WEST SUSSEX COUNTY COUNCIL CONSULTATION

TO:	Arun District Council FAO: Maria Tomalova
FROM:	WSCC - Highways Authority
DATE:	20 August 2020
LOCATION:	First Floor Office 44B Summerley Lane Bognor Regis PO22 7HX
SUBJECT:	FP/131/20/PD Notification for Prior Approval under Class O for change of use from a use falling within Class B1(a)(offices), to a use falling within Class C3 (dwellinghouses) -change of use of the existing 1st Floor Office to a self contained Studio Apartment. This application is Not CIL Liable as flat in Zone 4.
DATE OF SITE VISIT:	n/a
RECOMMENDATION:	Advice
S106 CONTRIBUTION TOTAL:	n/a

Block Plan

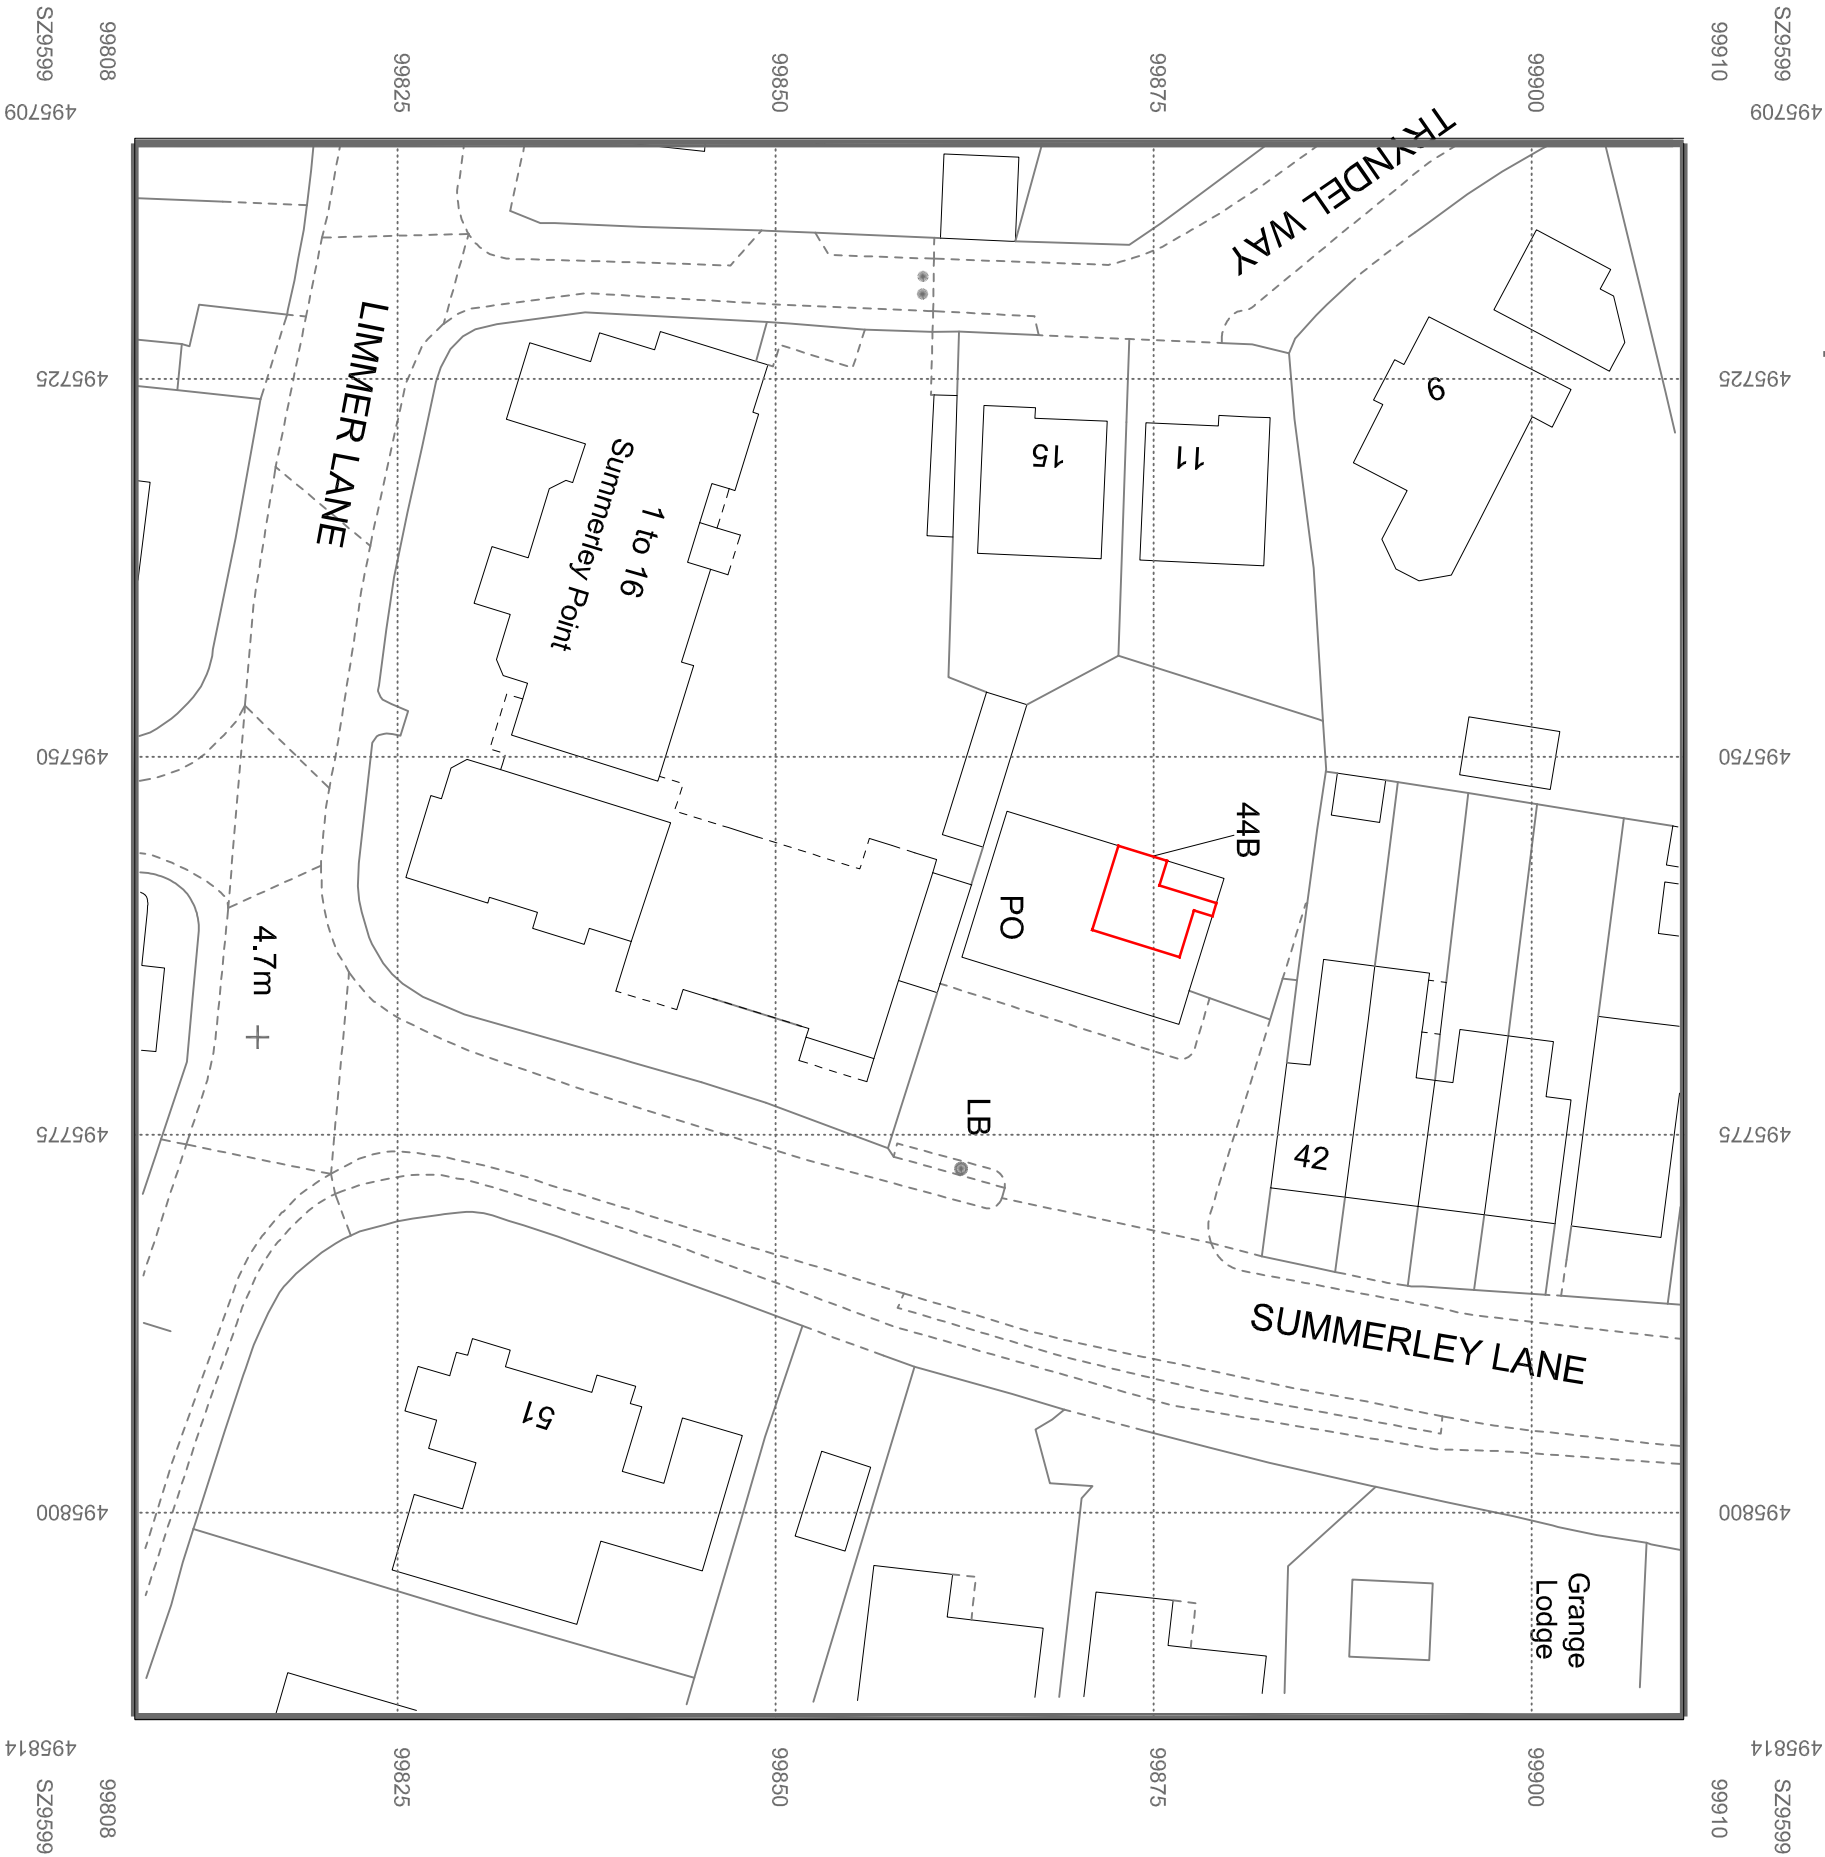
No alterations to the existing access to the site are proposed. The access will be shared with the existing retail use of the ground floor and existing residential use of the second floor. An inspection of data supplied to WSCC by Sussex Police over a period of the past five years reveals that there have been no recorded injury accidents within the vicinity of the site. Therefore there is no evidence to suggest that the existing access is operating unsafely or that the change of use would exacerbate an existing safety concern.

The proposed parking provision of two parking spaces is anticipated to be sufficient for a dwelling of this size and location. In addition, the LHA appreciate the sustainable location of the site, situated within close proximity to local shops, schools and bus services, and consider that there are viable options for sustainable modes of transport to reduce the reliance upon the private car. Furthermore, the LHA anticipate that the level of traffic generated by this proposal would not result in an increase over the potential traffic generated through the office use.

If the Local Planning Authority is minded to approve the application, they may wish to secure car and cycle parking via condition.
